# PEERLESS FARMS CONSTRUCTION DOCUMENTS

## 16975 FALCON HIGHWAY, PEYTON, CO

PEERLESS FARMS  
EL PASO COUNTY, COLORADO  
COVER SHEET  
CONSTRUCTION DOCUMENTS

**Earth Dikes and Drainage Swales (ED/DS) EC-10**

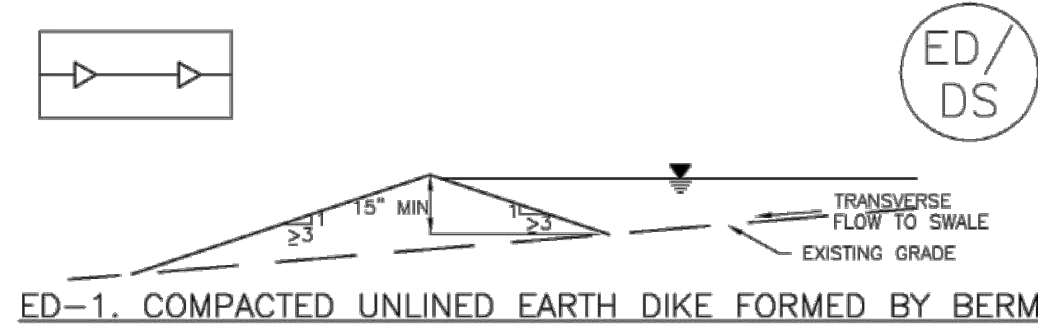
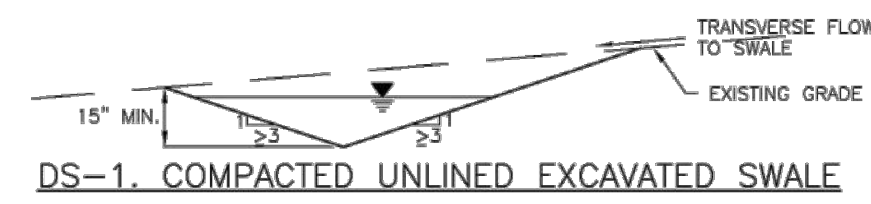
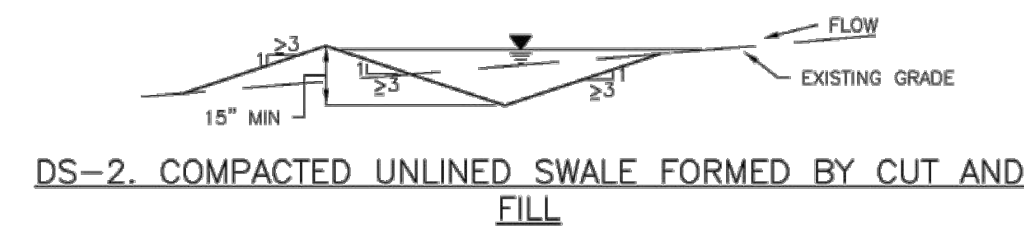
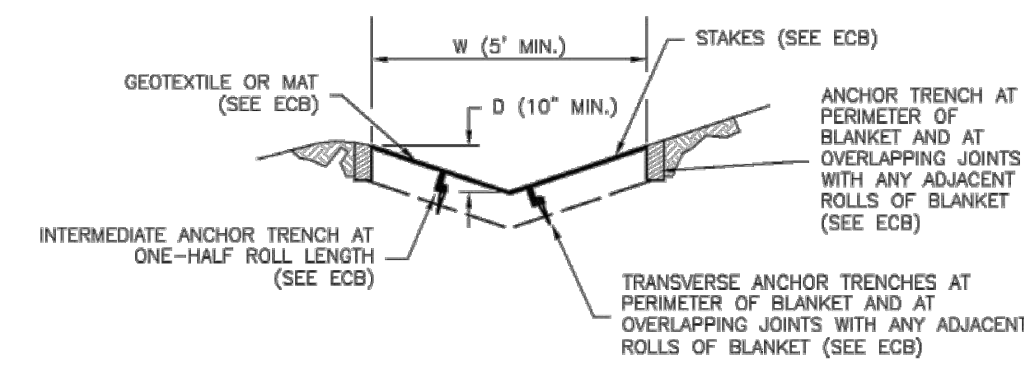
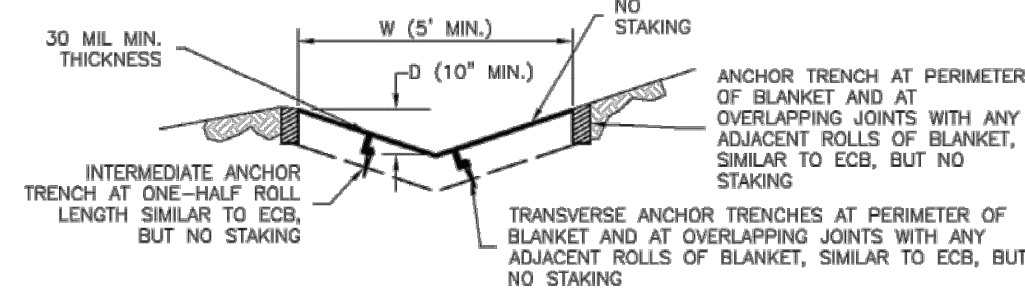
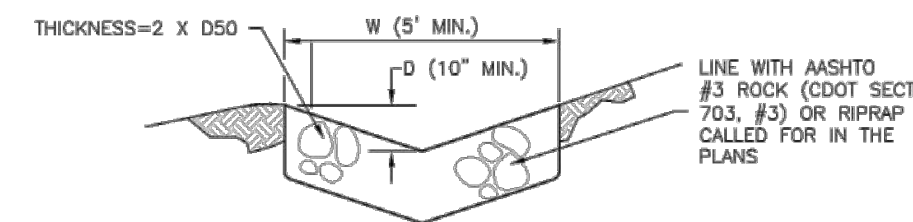
Unresolved from Submittal 1: Provide a detail of drainage ditch cross section with side slopes, min depth, etc.

Submittal 2 addition: The detail on sheet two shows two different cross sections, one that is not applicable if appears since the slopes are 4:1 and only one has a min depth listed. It needs to be clear the proposed side slopes (both front and back) and min depth for the construction of these ditches since they are providing drainage and water quality.
